Comment from Clymping Parish Council on Planning Application CM/23/17/PL

APPLICATION NO: CM/23/17/PL

Site Address: Land at Entrance to Waterford Gardens
Horsemere Green Lane Clymping BN17
5PQ

Description of Works: Erection of 1 No. dwelling with
detached garage (resubmission of
CM/29/14/PL). This application is a
Departure from the Development Plan.

Site Plan

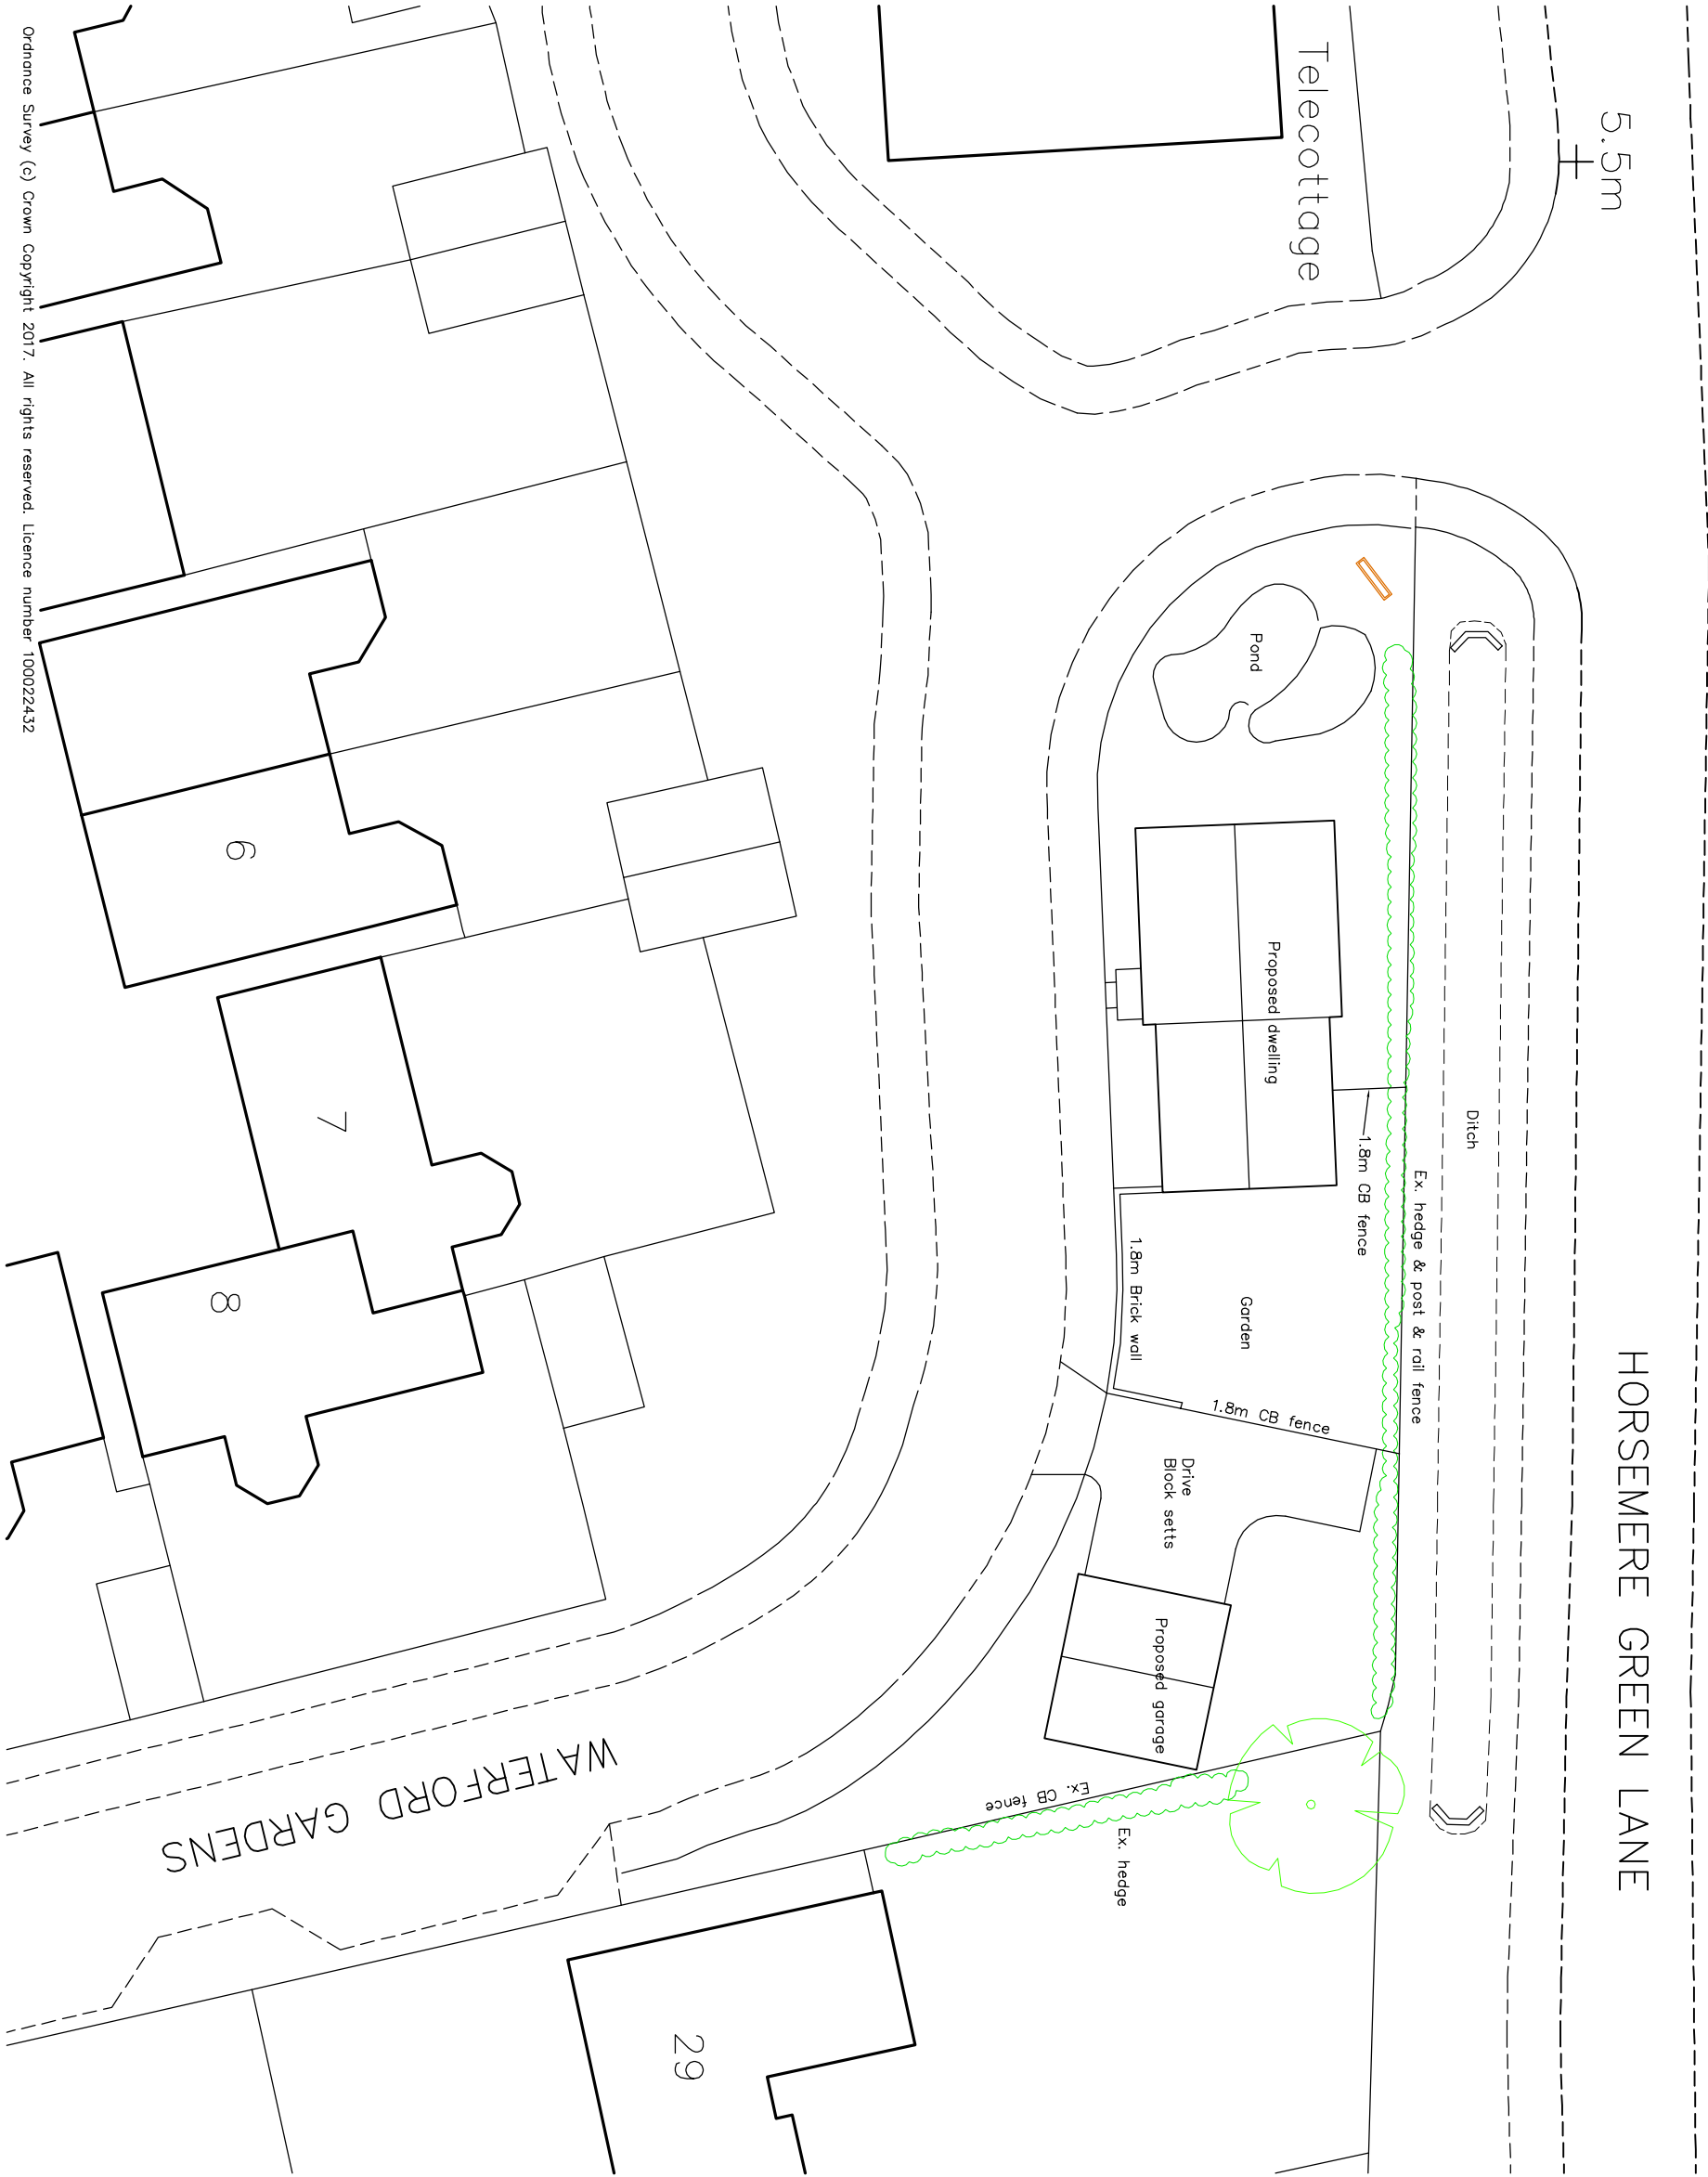
Council has no objection to this application **provided** the case officer is satisfied that the development is not detrimental to the street scene.

For information, the entrance to Waterford Gardens with its pond and landscaping is an attractive entrance to the Estate and makes a positive contribution to the street scene along Horsemere Green Lane. The site is also used by local children as an area for play. The proposed development is in front of the building line of the next road - Crophorne Drive
